**Recommended Conditions of Approval
Dolwende Sandstone and Gravel Quarry - Hollydeen (SSD 6519)**

I refer to the document titled "Dolwende Quarry Project Environmental Impact Statement Upper Hunter Holdings Pty Ltd" prepared by KMH Environmental and dated 3 December 2015 (the EIS) received by the Environment Protection Authority (EPA) on 11 December 2015.

ATTACHMENT 1**DOLWENDEE QUARRY (SSD 6519)
RECOMMENDED CONDITIONS OF APPROVAL**

Figure 3: Processing area layout

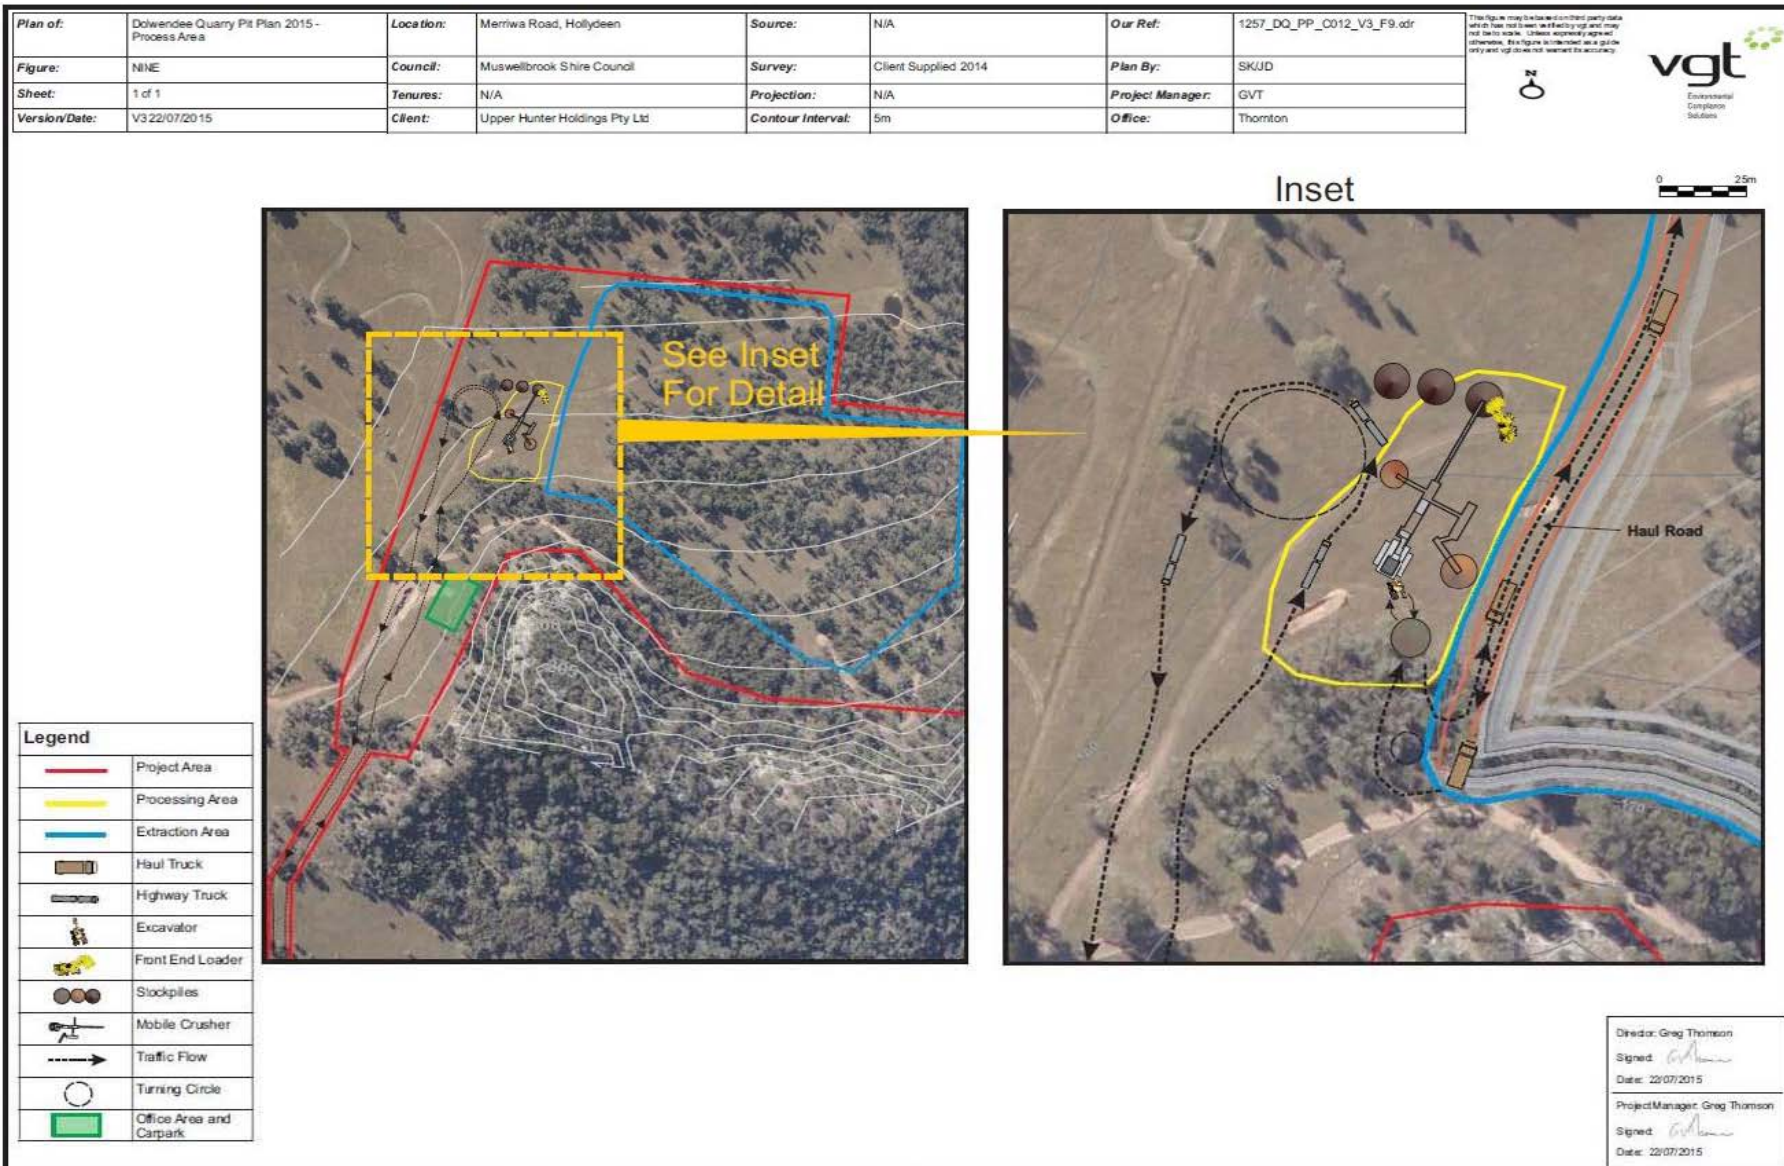
Minimal information is provided in the EIS regarding the proposed siting of the package sewage treatment plant and irrigation area. For this reason the EPA has been unable to make an assessment of the suitability of the proposal plant. Given the plant will service a maximum of 8-10 people, the EPA is satisfied that information regarding the placement and design of the plant and effluent management system can be provided with the Environment Protection Licence (EPL) application. This information will need to include details of the irrigation area including an assessment of the soils, a water balance, nutrient balances, and details of appropriate application rates.

The AQIA also indicates that no control efficiency has been applied to the 3rd highest emission source – being screening gravel material. The EPA considers that water sprays would be practical for an operation of this size. A condition requiring air emissions controls to processing equipment has been included at Attachment 1.

Figure 6: Conceptual soil and water management plan

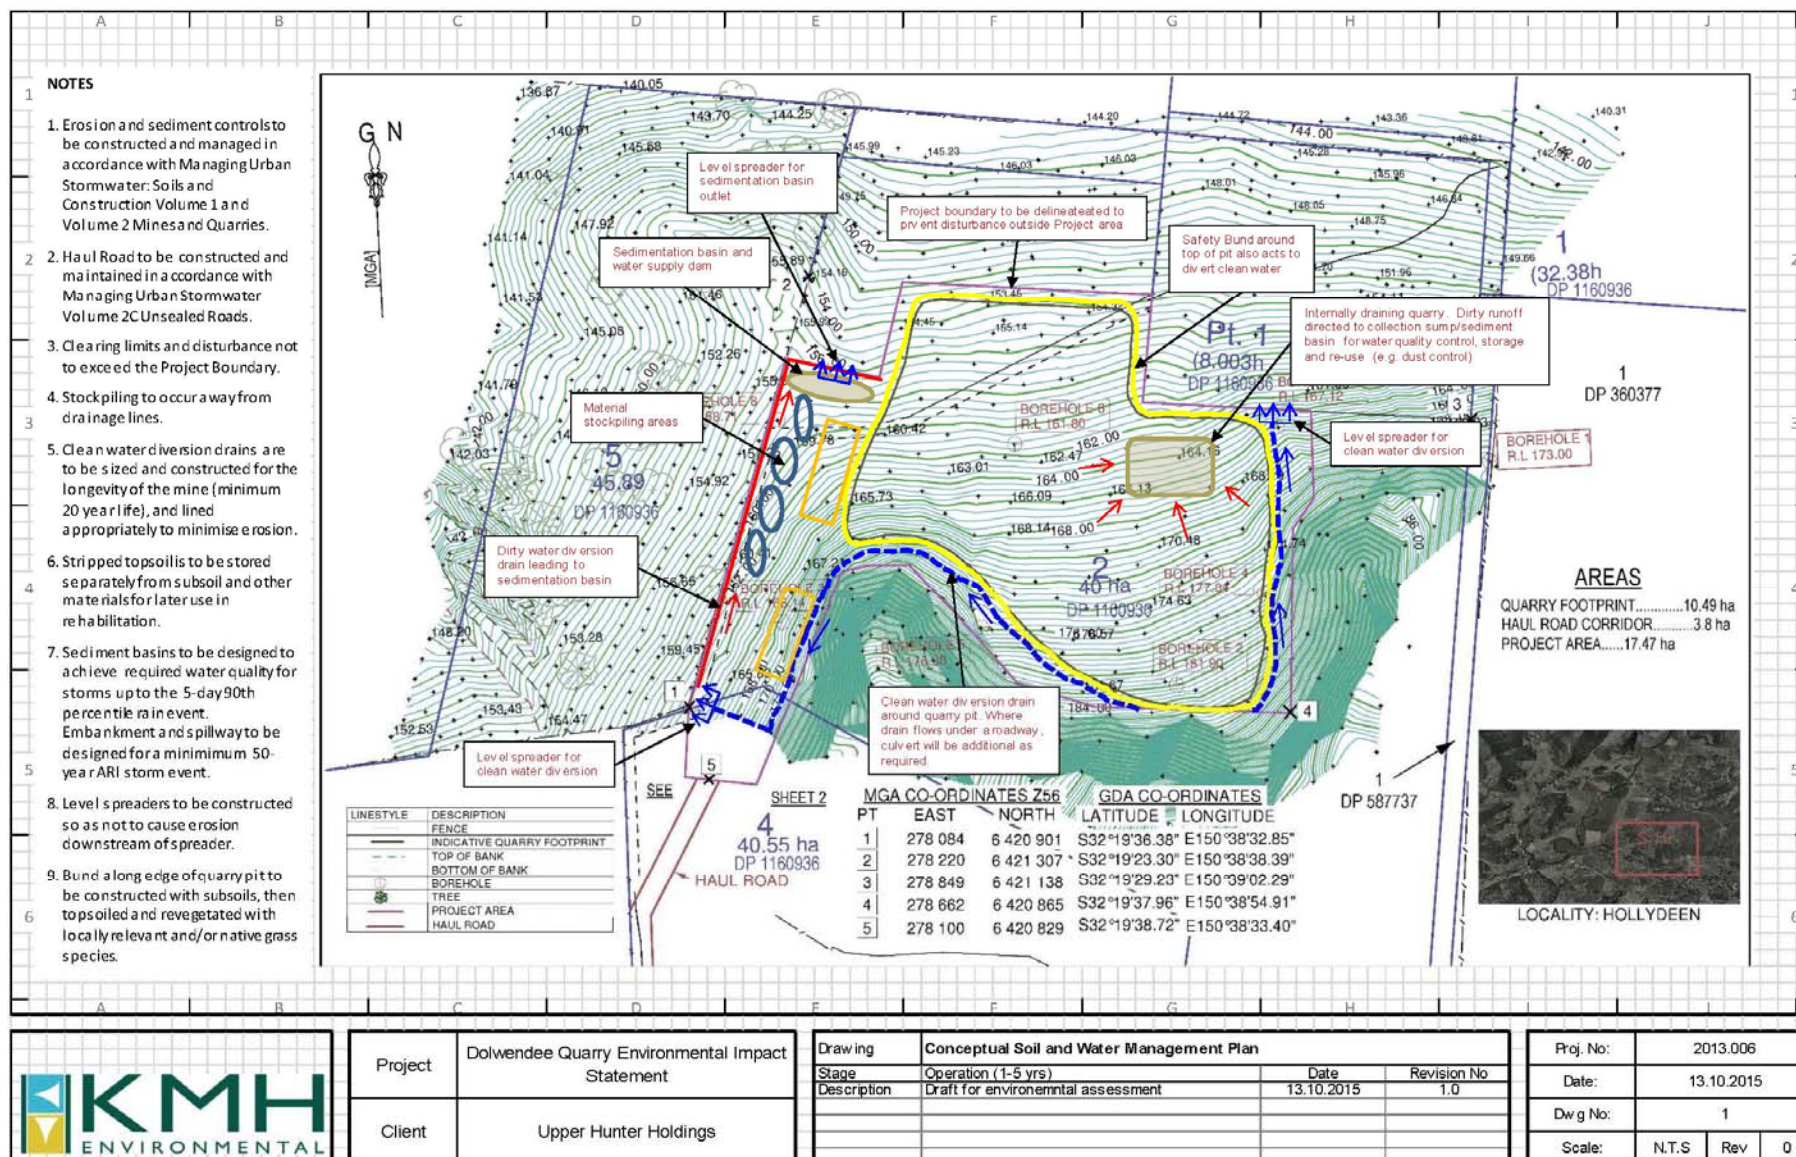
The EIS indicates that discharge from sediment dams may be required (EIS, Table 73 pp159-156) and suggests water quality criteria for planned discharges. The proponent states in the EIS that a tributary impact assessment for proposed discharges was not completed (as required by the EPA's Secretary's Environmental Assessment Requirements (SEARS)) because saline discharges are not proposed.

However, the Protection of the Environment (Hunter River Salinity Trading Scheme) Regulation 2002 defines saline water as water having an electrical conductivity (EC) of 400uS/cm or greater. Given the current site conditions is likely that sediment dam discharges would exceed this level of salinity.

The proponent must be aware that if it is intended that any discharges are authorised by the conditions on the EPL, discharge can only occur in accordance with the Hunter River Salinity Trading Scheme (HRSTS) operating rules. This includes holding sufficient salinity credits to authorise the discharge, installing real-time flow and conductivity monitoring at the point of discharge and only discharging when the HRSTS is operating.

As the EIS has made no assessment of the impact on the receiving tributary of off-site discharges, the EPA will not authorise any discharge from the site in the EPL until an adequate tributary impact assessment has been completed in accordance with the SEARS.

Figure 7: Layout of haul road from quarry

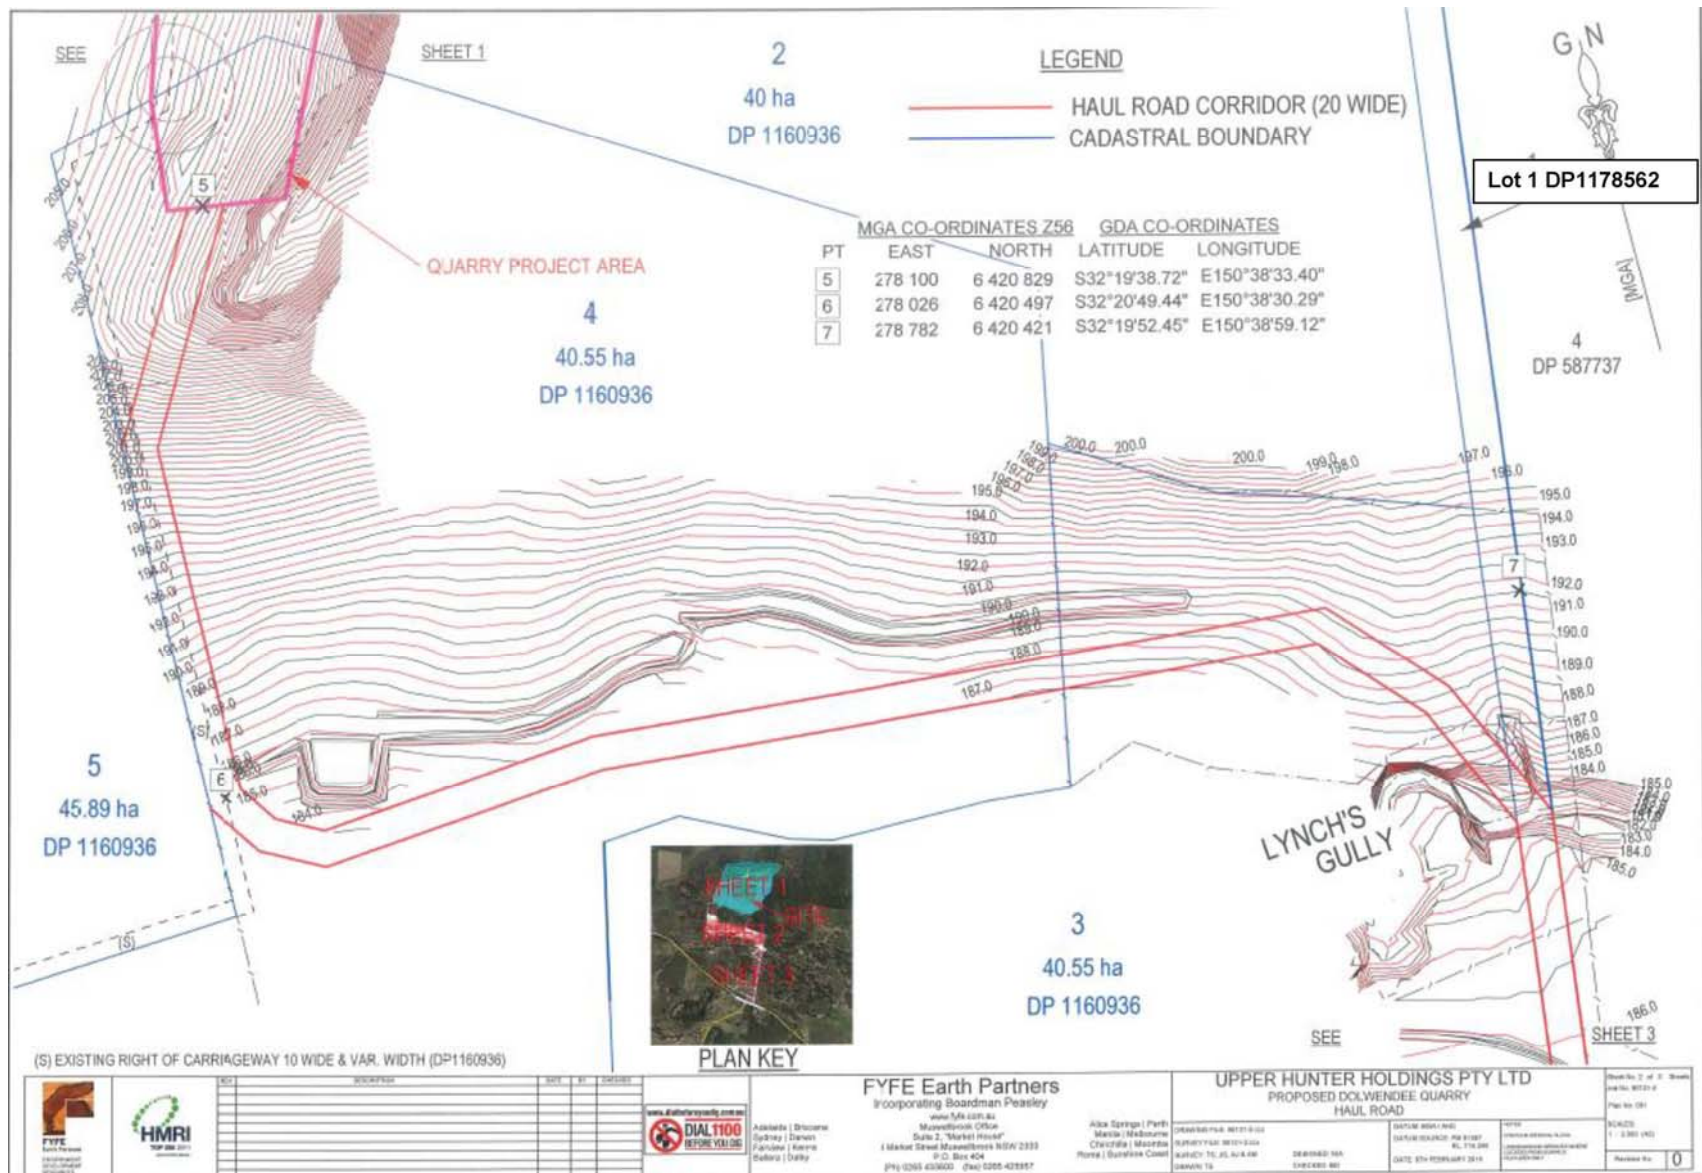
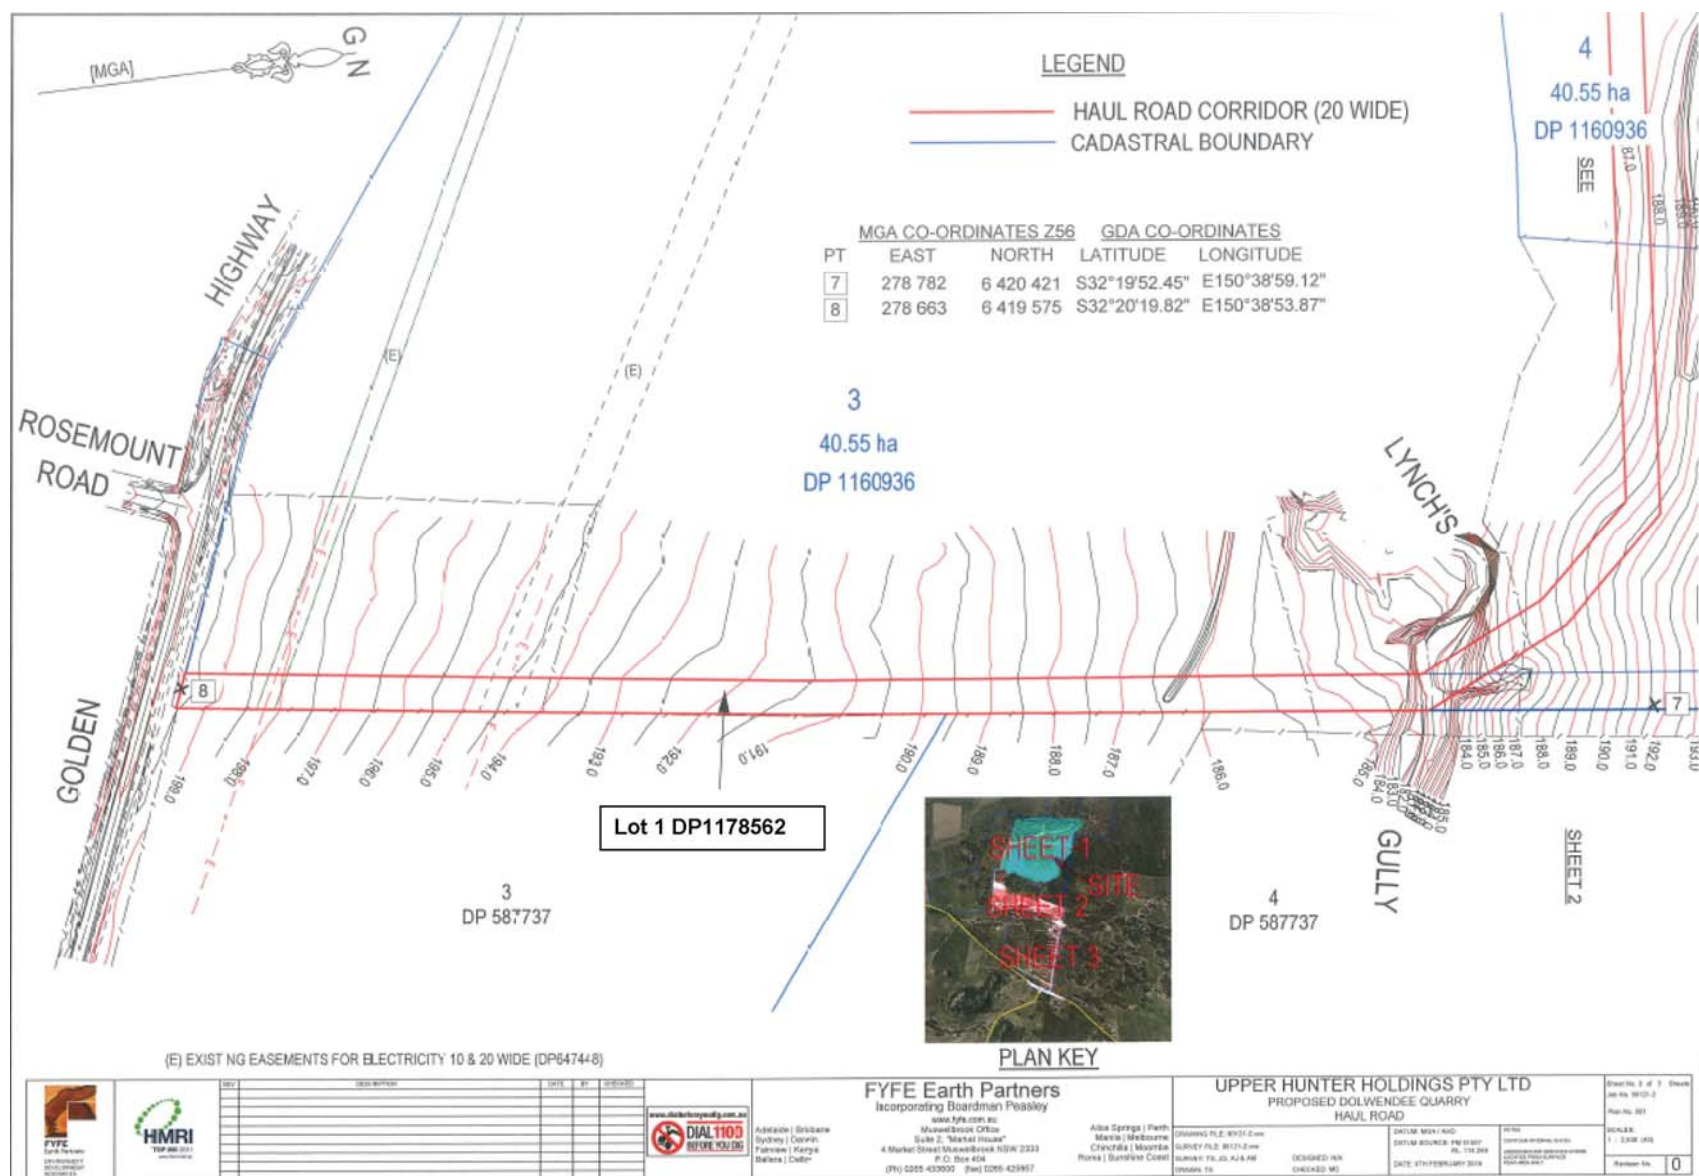
The top emission source is hauling, followed closely by wind erosion of exposed areas. This is similar to coal mine assessment in the Hunter Valley.

The EPA notes that the AQIA assumes a haul road control efficiency of 75%. Coal mines have demonstrated that a minimum 80% control efficiency through watering alone is achievable. The recommended conditions at Attachment 1 recommend a minimum 80% control efficiency.

- 2.5 All haul roads must be constructed and maintained so that a minimum 80% control efficiency of haul road dust is achieved.
- 2.6 The proponent must provide with the Annual Return for each reporting period a report detailing the actual area of exposed (disturbed) land against the predictions made in the EIS.
